20 December 2010

Re: Bungaribee Industrial Estate – Infrastructure (MP 08_0225) – response to RTA submissions

BUNGARRIBEE INDUSTRIAL ESTATE
INFRASTRUCTURE WORKS
MASTERPLAN
Development Application
Drawn: ABS, Checked: ME, Approved: GG, Scale: 1:2500 @ A1, Date: 01/09/10
Project Number: 208027, Drawing Number: LD DA 1002, Revision: 02

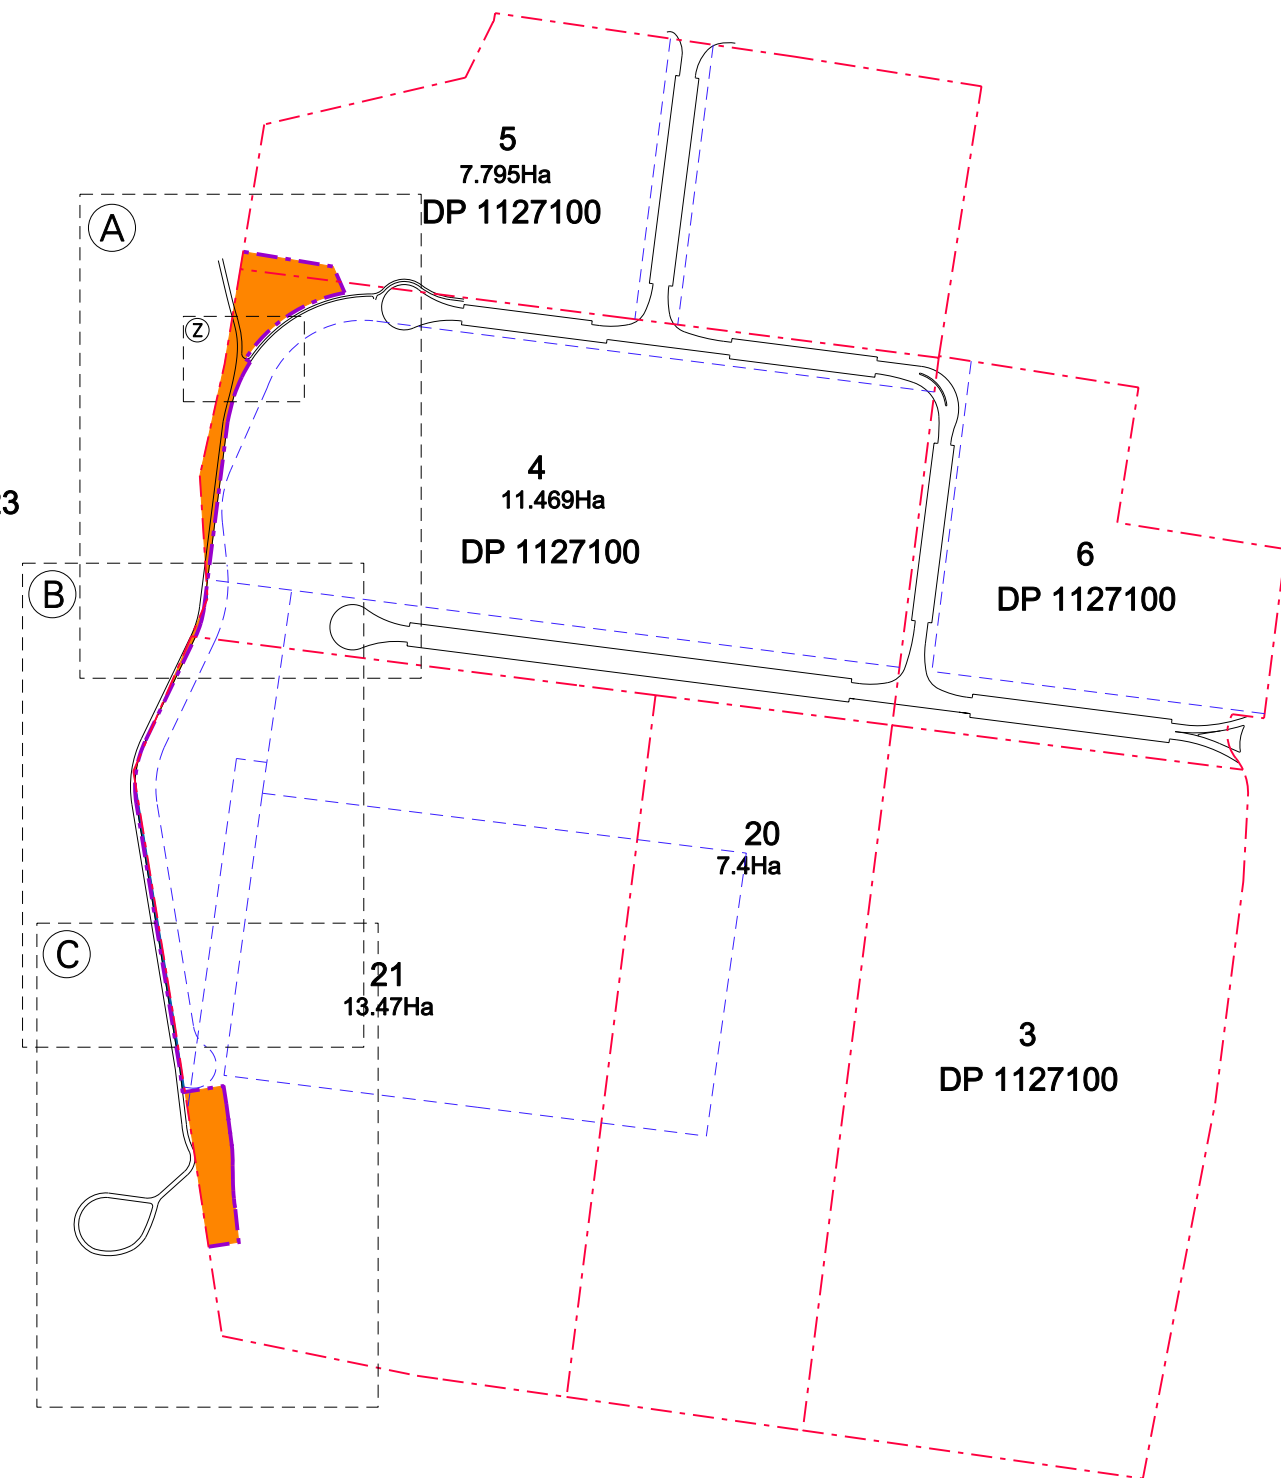
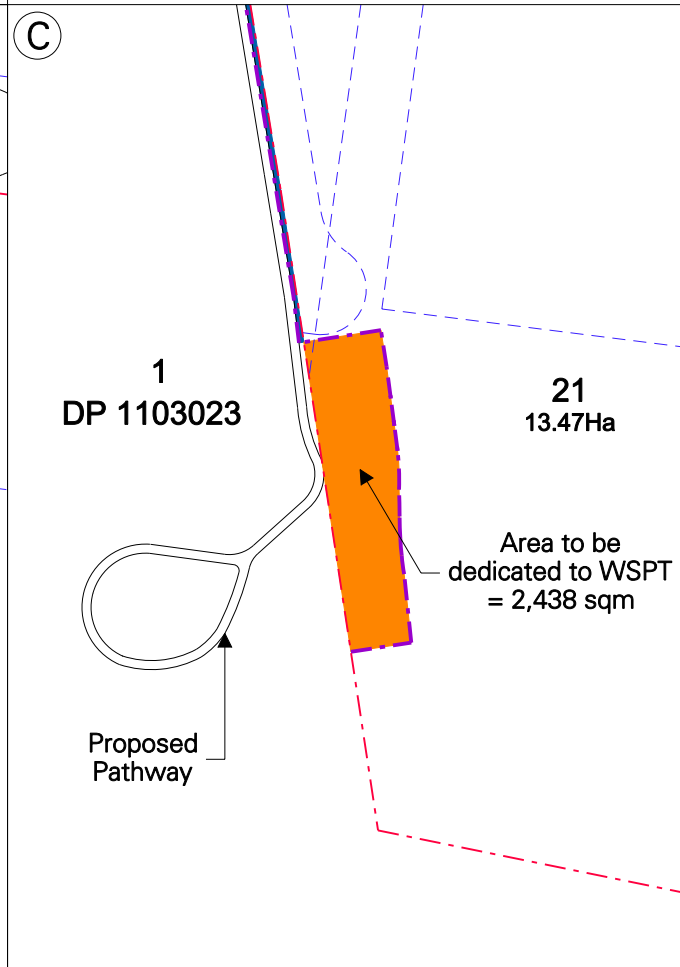
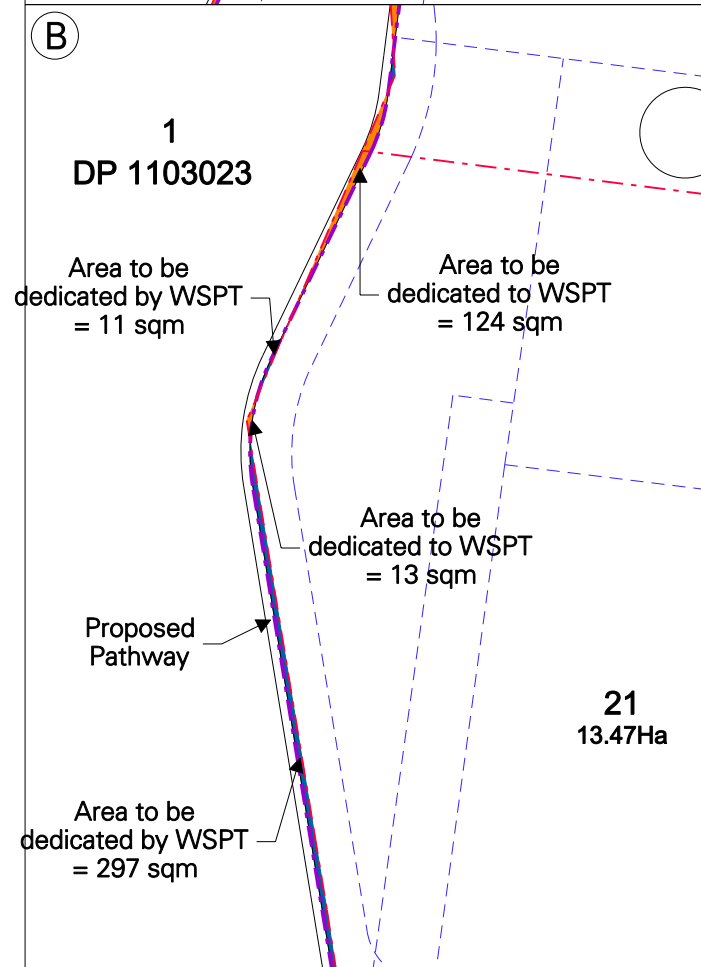
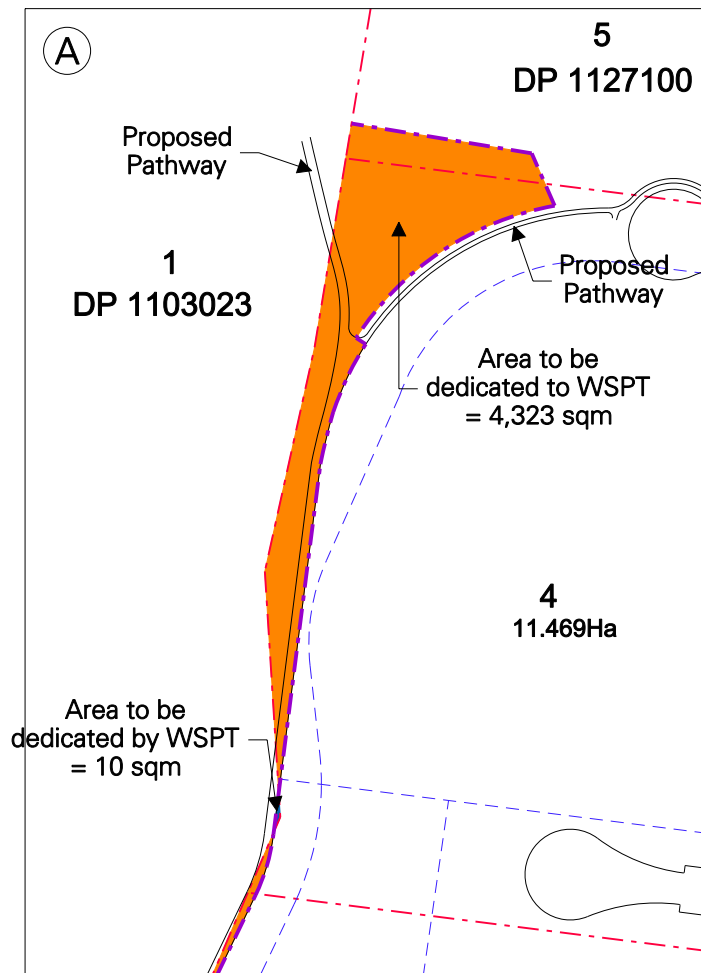
A 3 metre wide shared pedestrian / cycleway shall be constructed to Blacktown City Council requirements within the proposed subdivision and a connection provided from the internal road network to the Great Western Highway and Brabham Drive.

The shared path in proposed Road No.1 is to be extended across the Great Western Highway to provide a link to the future shared path to be constructed on the northern side of the Great Western Highway (Page 20)

In addition to the above, a 3 metre wide shared pathway shall be provided along Brabham Drive to establish a direct link from the shared pathway at the intersection of Brabham Drive and proposed Road No.4 to Blacktown City Council's proposed shared path to Doonside and Doonside Railway Station – as identified in Figure 9 – Cycle network (Source Blacktown City Council Liaison, 2006), page 20, Bungarribee Industrial Estate, Traffic Impact Assessment.

A 3m wide cycleway will be provided to the Huntingwood Drive extension (Road 4) connecting Brabham Drive with the new 3m wide cycleway to be provided within the Western Sydney Parklands. The parklands cycleway will be connected to the new 4-way intersection at the Great Western Highway along with the appropriate cycleway crossing. Roads 1, 2 & 3 will not be provided with a 3m cycleway due to road reservation constraints.

As noted above, Road No.1 does not contain a shared path, the connection to the Great Western Highway intersection will be via the parklands cycleway. Appropriate crossing design will be provided at the intersection and extended to the north of the Great Western Highway for future parklands use.

Goodman agree to providing a 3m shared pathway to the extent of Lot 6 in DP1127100 as this forms part of the future Goodman estate, however provision of extended bike-path beyond this area to the Great Western Highway will be subject to detailed design and discussions with the appropriate land owners at the time.
